Ribble Valley Borough Council
Housing & Development Control

Your ref 3/2022/0082
Our ref D3.2022.0082
Date 24th February 2022

Application no: **3/2022/0082**

Address: **The Old Garage Site Newton Road Dunsop Bridge BB7 3BB**

Drawing file: planx_downloads / 22_0082_Proposed_Site_Plan.pdf

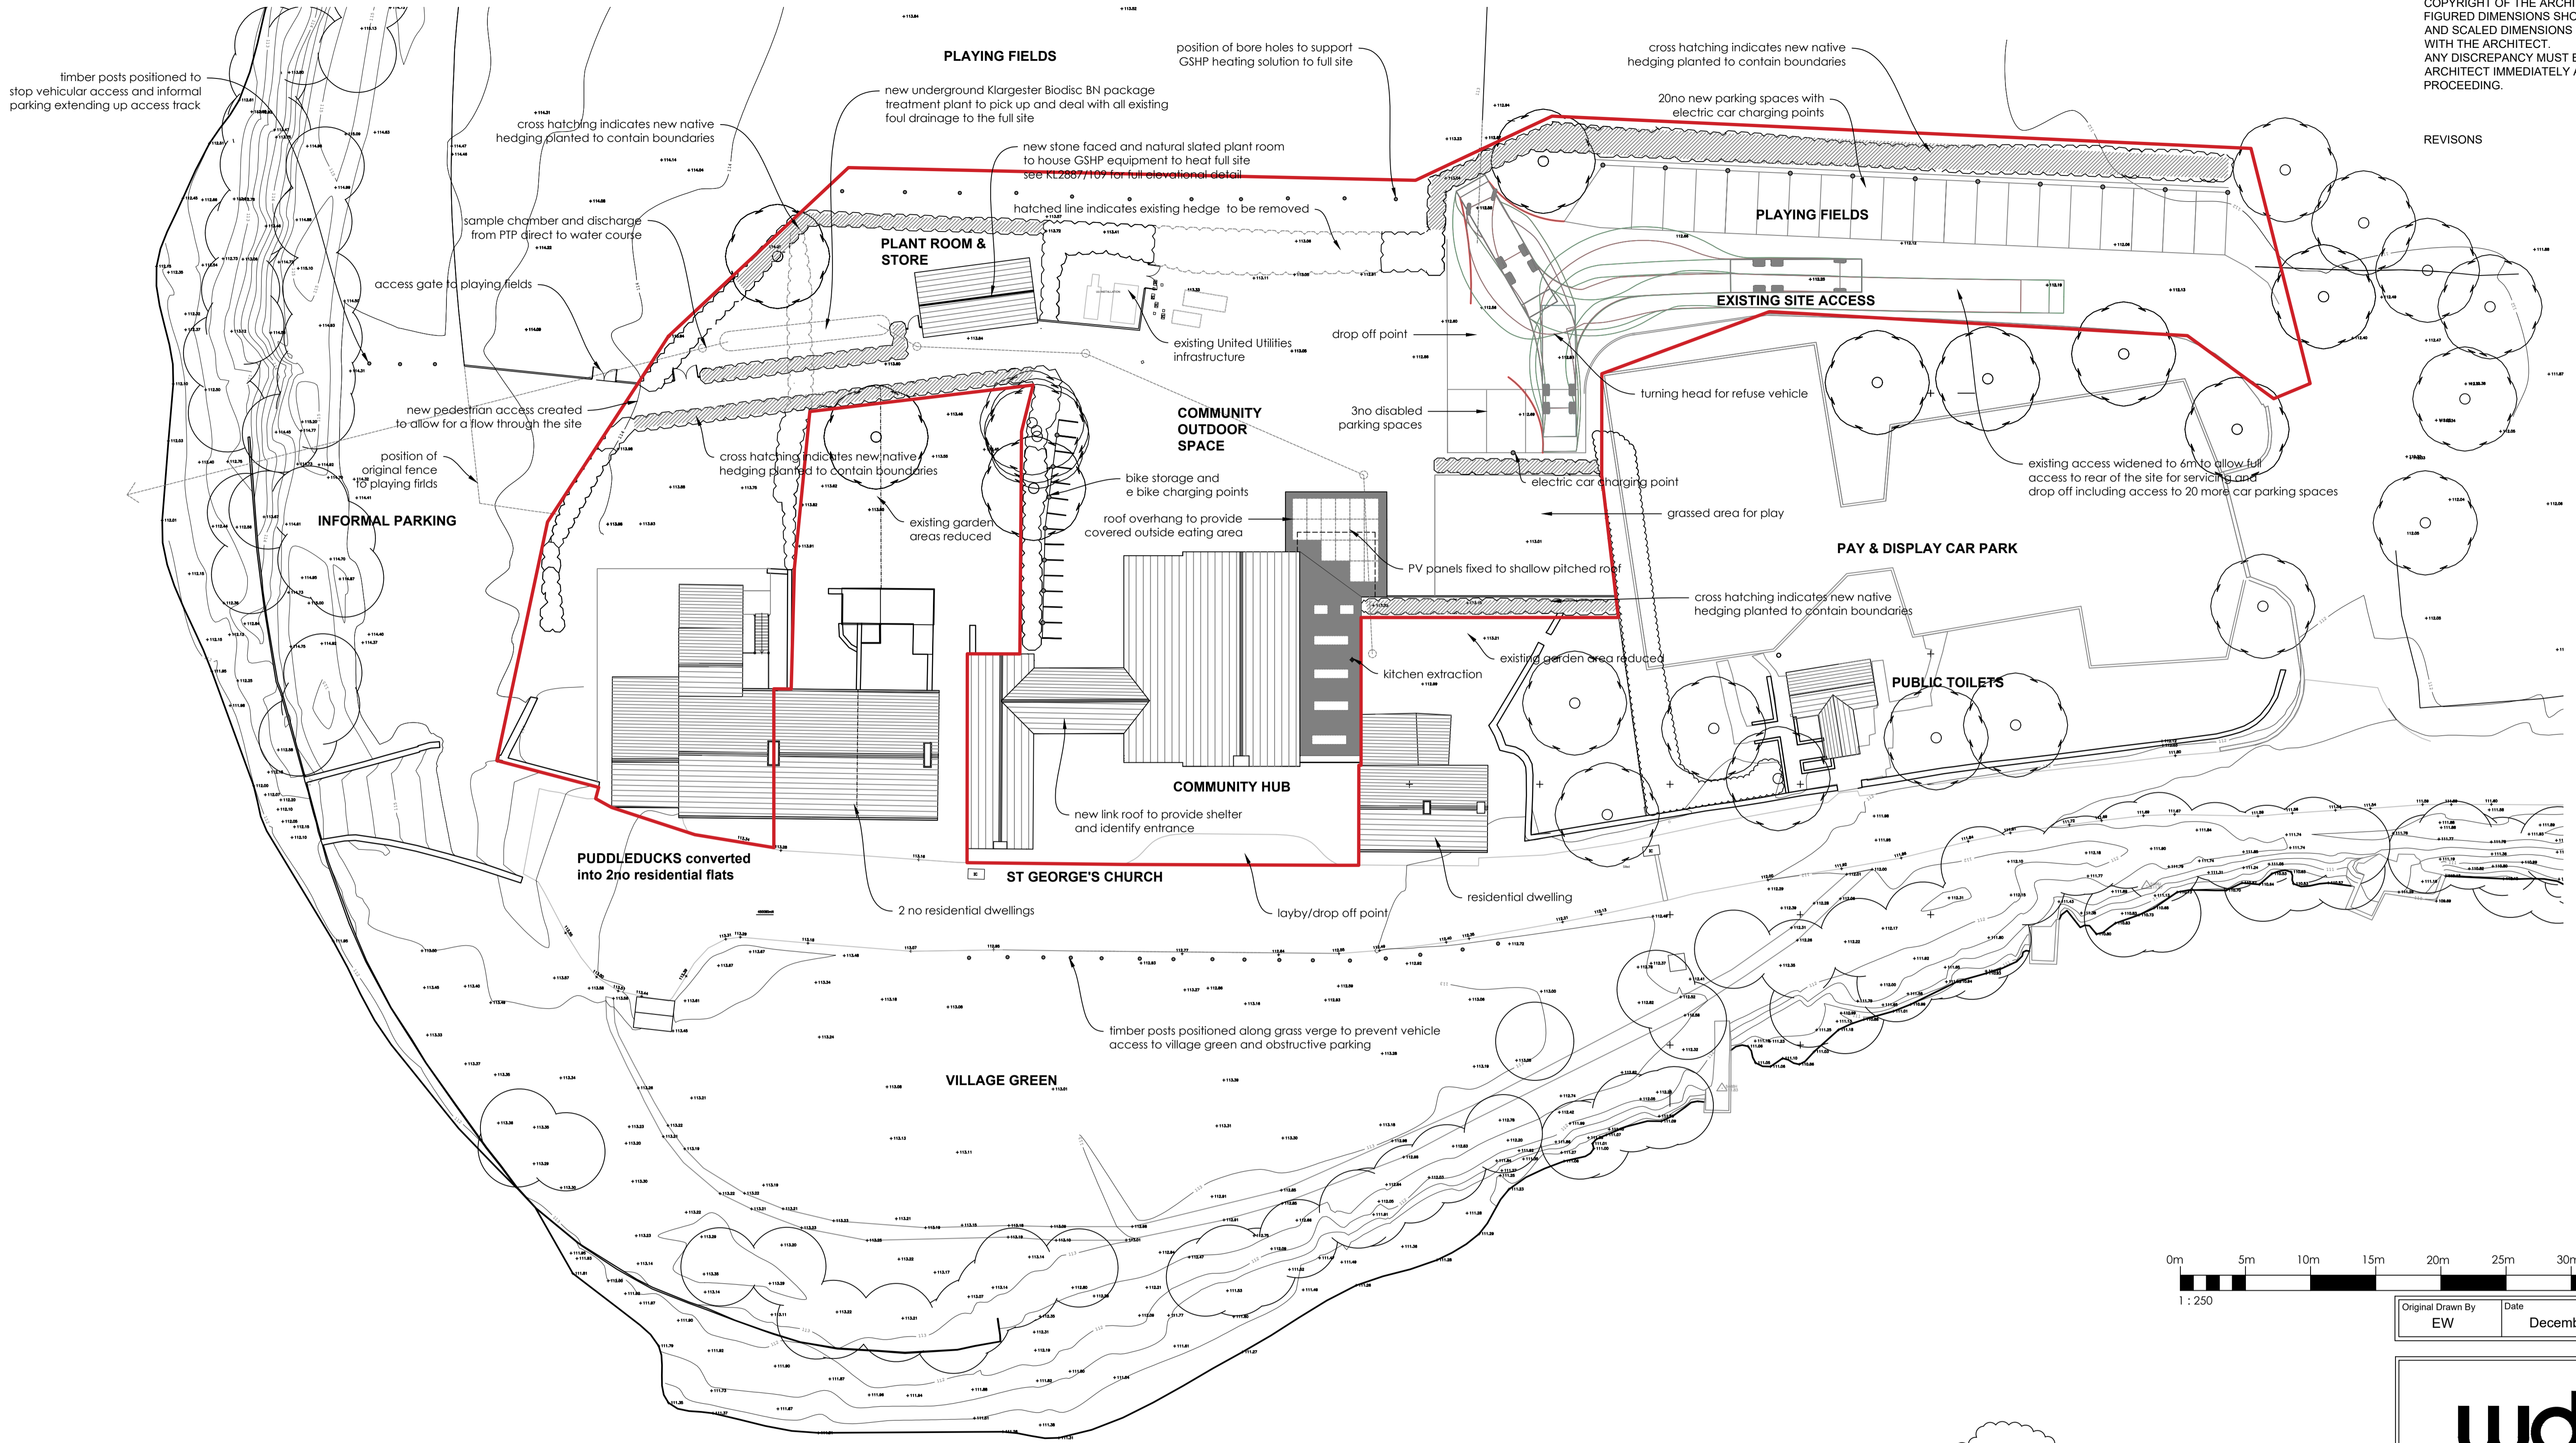
The first access is to the front of the site and as shown on WDP drawing number 105 titled "Proposed Site Plan and Block Plan," the access will be used as a lay-by/ drop off point for deliveries and for short-staying customers.

The LHA have reviewed the dimensions of the proposed lay-by/ drop off area and are aware that they measure approximately 13.8m in length and 2.4m wide. Therefore, the LHA are aware that 2 vehicles parked in a parallel formation are likely to be able to park in this area at any one time.

However, while the LHA are aware that the area was used as part of the garages forecourt and so vehicles used the area every day, the LHA are unable to support the continued use of this area following the proposal. This is because the LHA are concerned about vehicular visibility in this location due to the Chapel and the dwelling, obstructing the view of Newton Road in both directions.

Should two vehicles be parked in the layby/ drop off area at the same time, they will also obstruct each other's view of Newton Road, which will be to the detriment of highway safety. Therefore, the LHA would advise that the area is removed and all vehicles to the site use the car parking area to the rear of the site, which is accessed from the Public Car Park.

If the Applicant insist the area is used, the LHA would require a visibility splay drawing showing that the area can provide the minimum visibility splays in both directions.

The Transport Consultant, PSA Design, in the Transport Statement have conducted a speed survey of Newton Road adjacent to the site on 27th July -2nd August 2021. The speed survey found that Newton Road experiences 85th percentile speeds of 28.4mph eastbound and 27.4mph westbound. Therefore, the LHA require at the lay-by/ drop off area, minimum visibility splays of 37m eastbound and 35m westbound. These should be provided on a revised plan.

The LHA are also aware that the Applicant is proposing to place timber posts across from the site on the edge of the "Village Green" as shown on the drawing. This is to prevent on-street parking from occurring in the area.

The LHA require these posts to be removed because rather than prevent on-street parking, vehicles will instead park further into the carriageway, reducing the width of Newton Road. The C classified road, as described in the Transport Statement, is a single carriageway and measures 6.75m wide. Therefore, the road is narrow for two-way movements to occur in normal conditions and should vehicles following the erection of the timber posts, park further into the carriageway, the width will be further reduced which will be to the detriment of highway safety.

The concerns regarding the timber posts is further exemplified should the lay-by/ drop off point at the front of the site be operational. This is because potential conflict points could occur when vehicles exit the lay-by and traffic is flowing in both directions. This is because vehicles trying to exit the lay-by will have to tackle poor visibility from the buildings obstructing the view of the road as well as vehicles further encroaching onto the public highway when parking on-street. Therefore, the LHA are concerned regarding highway safety and so request that these posts are removed to leave the area as existing.

As already mentioned, the secondary access to the site is provided from the existing Public Car Park owned by Ribble Valley Borough Council. The application is proposing to add 23 additional spaces for the development, as shown on WDP drawing number 105 titled "Proposed Site Plan and Block Plan."

The LHA have reviewed the access serving the Public Car Park and are requesting that a revised swept path analysis drawing is submitted showing a refuse vehicle is able to enter and exit the site in a forward gear. This is because currently the swept path only shows the refuse vehicle using the carriageway internally.

The LHA have reviewed WDP drawing number 105 titled "Proposed Site Plan and Block Plan," and are aware that the site will provide 23 car parking spaces which will include 3 disabled bays and multiple electric vehicle charging points. Visitors to the site will also be able to use one of the 39 bays which are located in the Public Car Park.

The LHA have also reviewed the proposed parking area and are aware that there is a lack of segregated pedestrian facilities from the car park to the rear of the site. Currently, pedestrians, when they have parked their vehicle, would have to walk in the carriageway to access the rear of the site and the proposed pedestrian link to Public Footpath 3-8-BW15. As a result, the LHA advise that a segregated pedestrian link should be provided where the hedge is located adjacent to the parking spaces on the plan. This will provide pedestrians with a safe link into the site.

However, the LHA have reviewed the swept path analysis found on WDP drawing number 105 and are aware that when the refuse vehicle turns around to exit the site in a forward gear, it will overlap one of the disabled spaces. This is unacceptable because should the 3 disabled spaces be used by parked vehicles, there will not be adequate space for a refuse vehicle to turn around and exit the site in a forward gear. Therefore, the informal turning head provided is inadequate.

Consequently, the LHA require a more formalised turning head to be provided at the site. This should be usable by refuse and delivery vehicles and should be shown on a revised site plan.

The LHA also require on the revised site plan, a delivery area for the site. The LHA require further information regarding the type of delivery vehicles which will service the site. The delivery area should then be tailored for that size of vehicle and a

tracking drawing should be submitted showing how the area will be used and how the vehicle will exit the site in a forward gear.

The LHA also have concerns regarding the drop off area which is located adjacent to the disabled spaces. This is because should this area be used, vehicles will inappropriately park, obstructing the informal turning head for refuse and servicing vehicles and will obstruct the use of the disabled bays. As a result, the LHA are concerned that vehicles obstructing these areas could cause conflicts to occur between vehicles. To prevent these concerns, the LHA require the drop off area to be removed.
